**Proposed F.A.S.T. (Future Automotive Speed
and Technology) Zone at Bicester Airfield
(19/02708/OUT):**

Aviation Safeguarding Review and Assessment

EAS/P1218/R1/Issue 1

Report prepared on behalf of Cherwell District Council

Figure 3 – [Wind Rose for Oxford Airport](#)

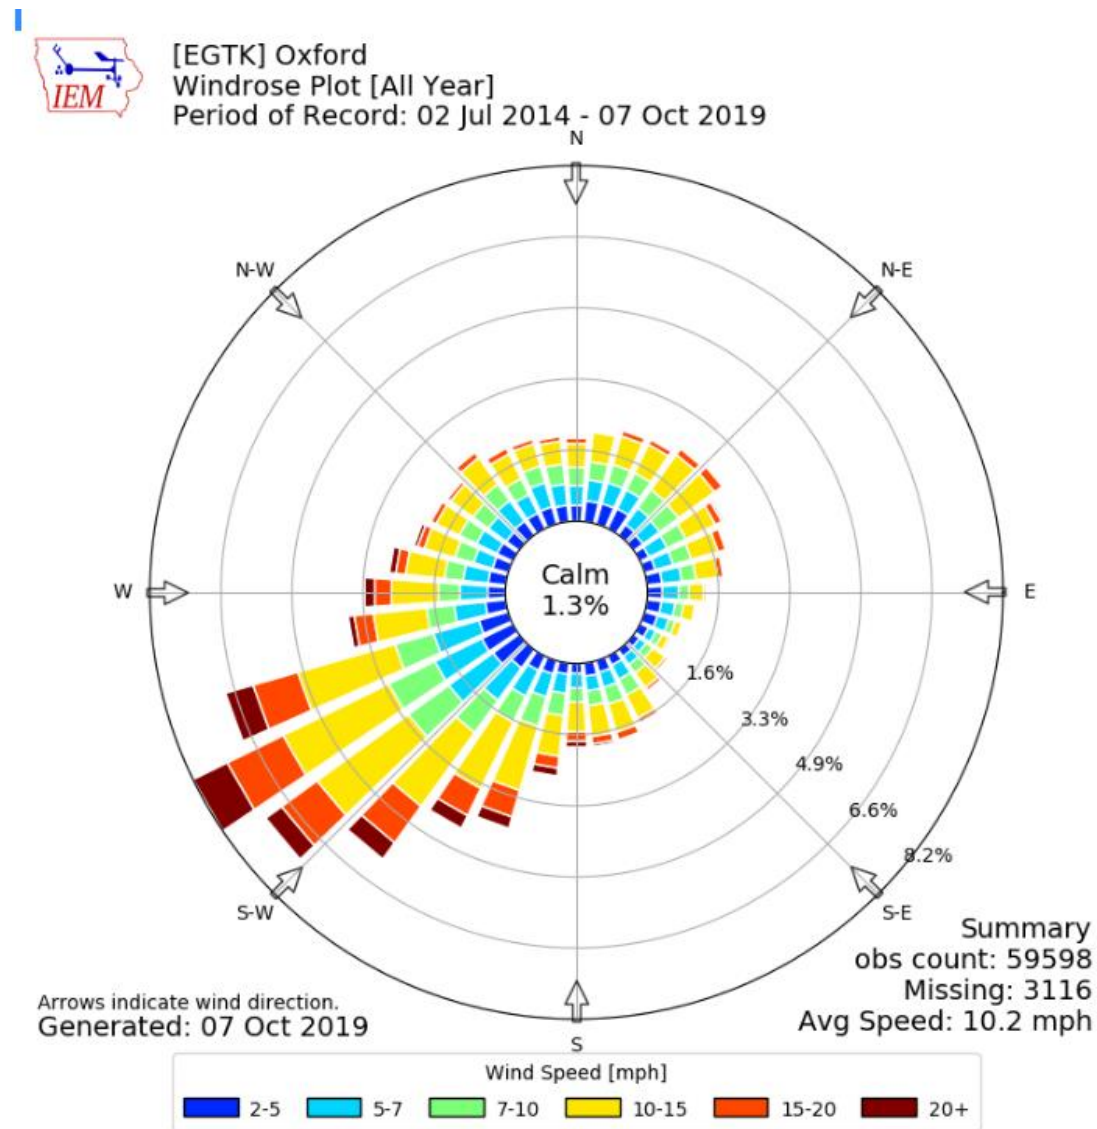
- 2.2 At Section 4, the report considers the dependence of airfield operations on wind conditions and presents a wind rose at Figure 4.1. The report goes on to state that *"it is clear that the majority (probably around 80 percent) of take-offs and landings, including glider launches by winch, will be in the R06/24 direction into wind."*

- 2.3 It is far from clear from the information provided in the ASA Report that the percentage of operations will be in the direction stated. In the first instance, the pictorial representation in the form of a wind rose does not translate readily from visual inspection into a numerical split. Secondly, the time period for the wind rose example is not stated so it is unclear whether it can be considered to be sufficiently representative of the longer term. Thirdly, whilst wind conditions are generally an important consideration in determining the preferred runway direction, they are not the only consideration.
